Application for a Non-Material Amendment Following a Grant of Planning Permission

Number	5
Suffix	
Property Name	
Address Line 1	Dovecot Close
Address Line 2	
Address Line 3	Hillingdon
Town/city	Eastcote
Postcode	HA5 2RE

Erection of singlr storey extension to the rear and conversion of integral garage to habitable accomodation

Minor amendment being alterations to fenestration on single storey rear extension pursuant to planning permission 5665/APP/2023/1337 for Single storey rear extension.

B. PROPOSED REAR ELEVATION

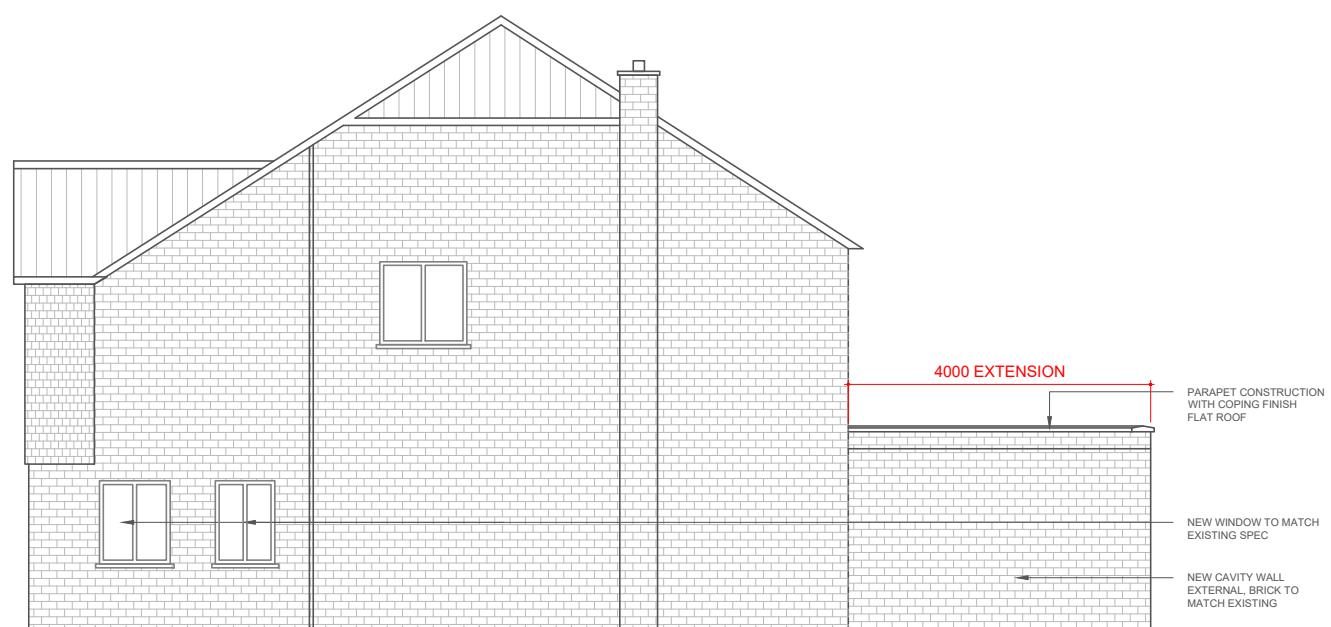
The proposal to omit the window and the door for new larger bifolding door to allow natural lighting into the property.

Proposed Floor Plans P3
Proposed Elevation P3
